Strategic Sites and Urban Renewal, Strategic Assessment

## Planning Assessment Report

### Application to Modify the Minister's Approval for the residential development at the Dan Land

#### Major Project 06\_0031 MOD 1

PROPOSED RESIDENTIAL SUBDIVISION Landscape Master Plan

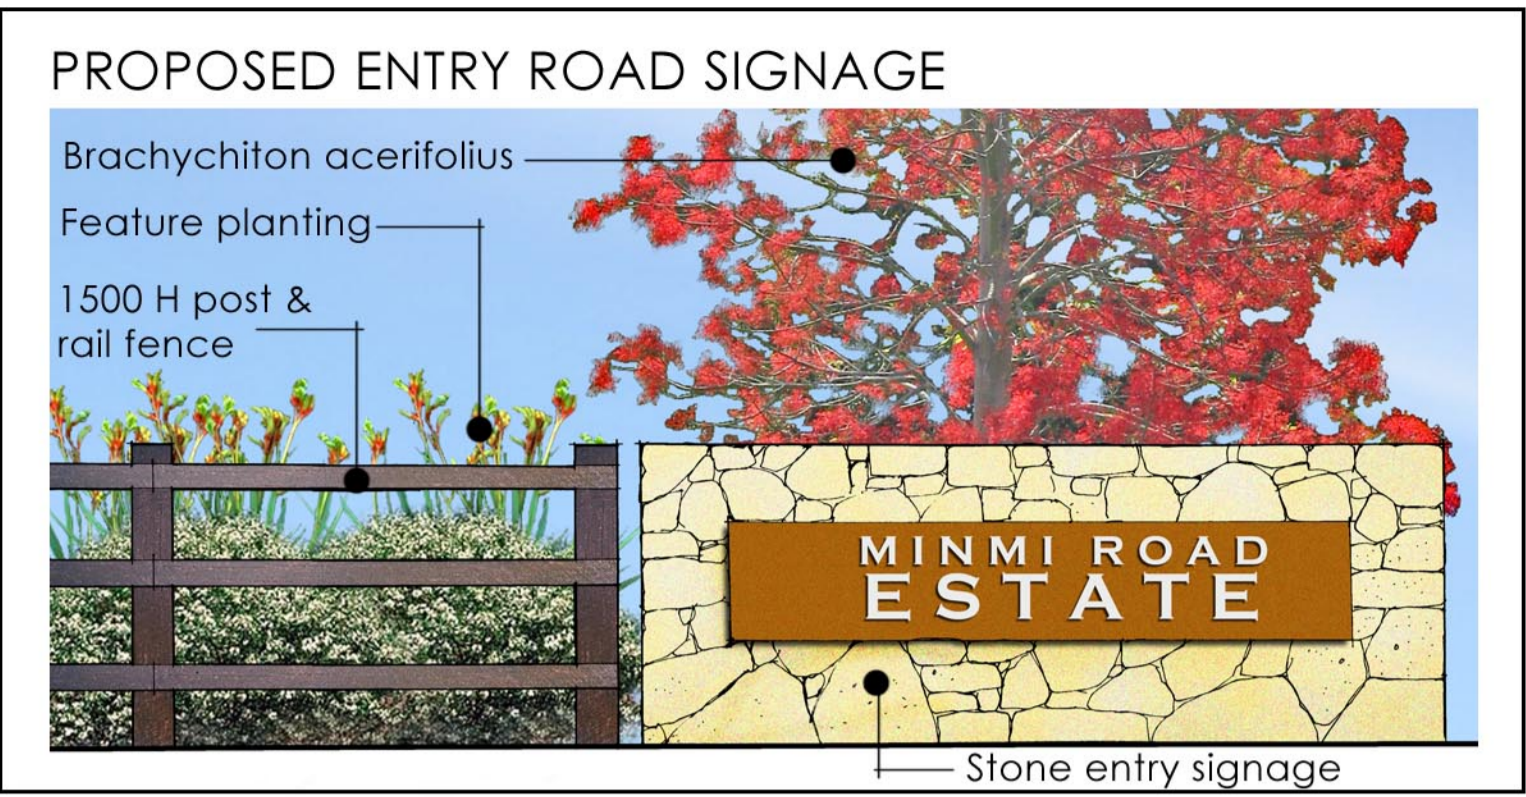
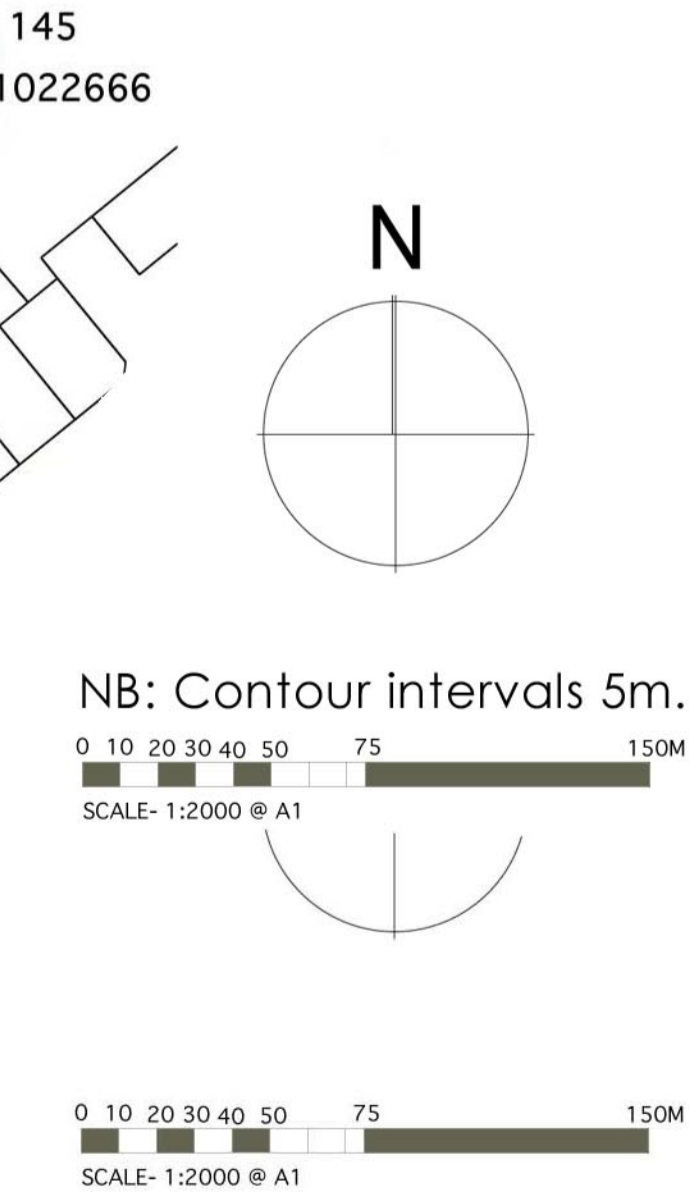
The Proponent is seeking to amend the approved Concept Plan to allow a swimming pool, tennis court, meeting rooms, change rooms and associated car parking facilities intended to serve the recreation needs of the residents of the Dan Land development in an area on the Concept Plan currently designated as a grassed "pocket park". The pocket park was effectively created through a modification to the Concept Plan requiring the deletion of all residential lots on the northern side of the perimeter road; covering only a very small portion of the 7(b) zoned land on the Site, on a plateau above the ephemeral wetland area (refer to Vegetation Management Plan at Tag F) and

The Department raises no objection to the proposed recreation area provided the area is maintained by the community association for recreation purposes. At this stage endorsement for the recreation facilities is in concept form only, with the detailed design and assessment to follow in a Part 4 development application to Council. It is therefore recommended that the approved Concept Plan drawings (Concept Plan, Landscape Master Plan & Vegetation Management Plan) be amended to reflect the intended active recreation uses.

**FIGURE 18: PROPOSED STAGING
OF DEVELOPMENT**
(Revised 18 May 2007)

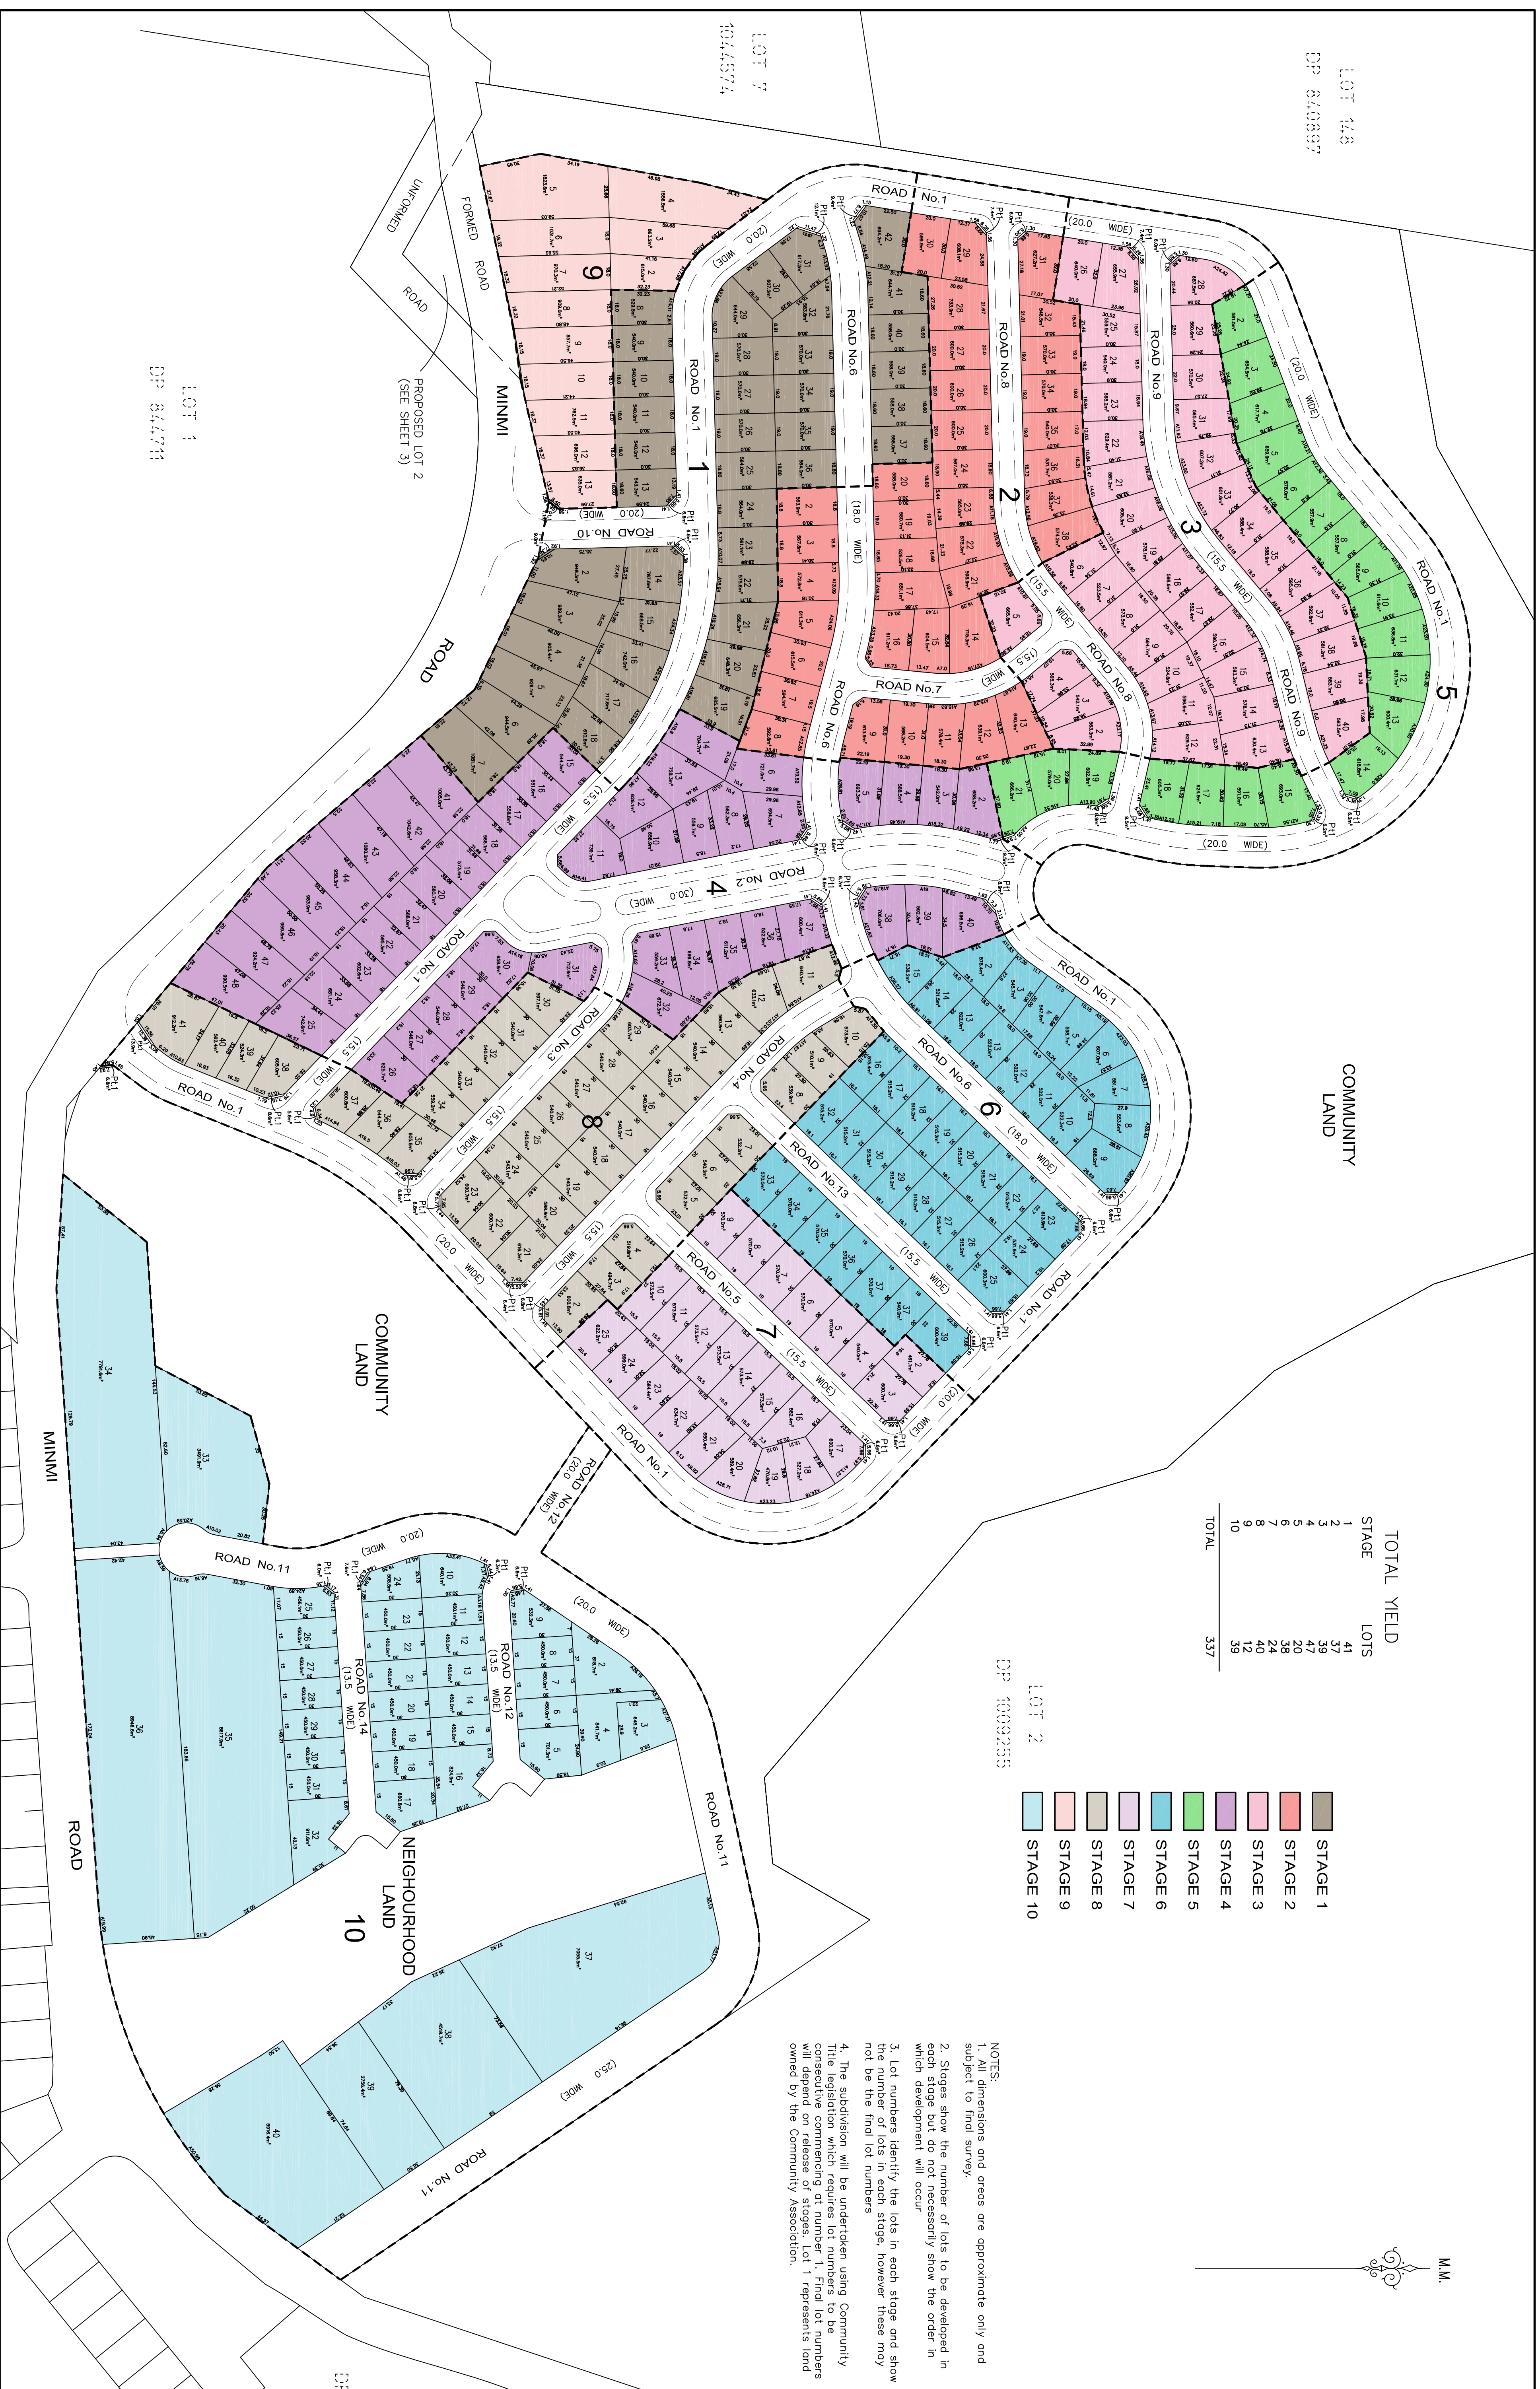
The Proponent explains in their submission that amendments to the staging plan are necessary as the engineering design process has identified constraints that were not taken into account in the original staging plan. These constraints include timing issues relating to road construction (cut and fill) and water and sewer servicing. The revised staging plan is shown at **Tag F**.

In its submission to the Department, Council outlines that the Proponent has lodged a development application with Council seeking approval for the establishment of an "Exhibition Village" on land within proposed Stage 1 and Stage 9. Council has recommended that land within Stage 9 be consolidated with Stage 1 to facilitate the construction of the Exhibition Village.

The Proponent has advised the Department however, that the model homes proposed for Stage 9 will not be constructed at the same time as Stage 1, rather, later in the life of the development when all Stage 1 model houses are expected to have been sold. It is therefore considered unnecessary to consolidate Stages 1 and 9 in the modified staging plan.

The revised staging plan is generally consistent with the approved Concept Plan as it does not involve any alterations to the subdivision layout approved in the Project Application, merely the timing of the release of various components. The revised staging plan will not have any implications for the future delivery of community facilities or infrastructure. No objection is raised to the approval of the revised staging plan.
